COUNTY OF HARNETT LAND USE APPLICATION
Central Permitting 108 E. Front Street, Lillington, NC 27546 Phone: (910) 893-7525 Fax: (910) 893-2793 www.harnett.org

JASON PRICE CONSTRUCTION, INC.
 THE WAKE
 LOT # 28 PERSIMMON HILL
 SCALE: 1"=50'

**Re: Status of Improvement Permit Application #08-5-19564 - Lt. 28
Persimmon Hills**

JASON PRICE CONSTRUCTION, INC.
 THE WAKE
 LOT # 28 PERSIMMON HILL
 SCALE: 1"=50'40"

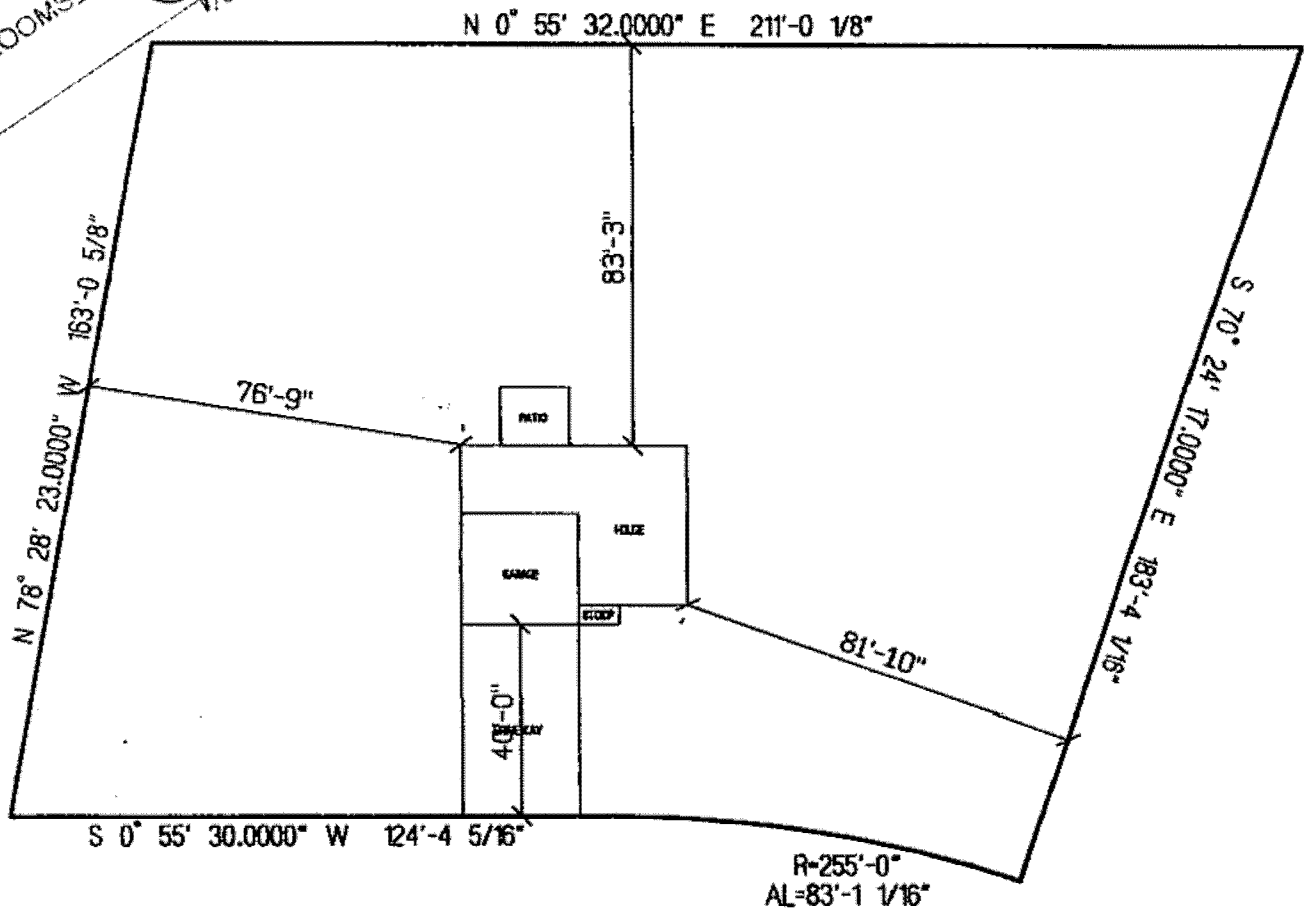
Required Residential Property Line Setbacks: Proposed Comments: 3/20 move house per E.H

- 1. Property lines/corners not marked or labeled
- 2. House corners not marked or labeled
- 3. Directions not clear to property
- 4. Property needs brush or vegetation removed
- 5. Backhoe pits required
- 6. Other – Move house as shown. Submit new plot plan to Central Permitting.
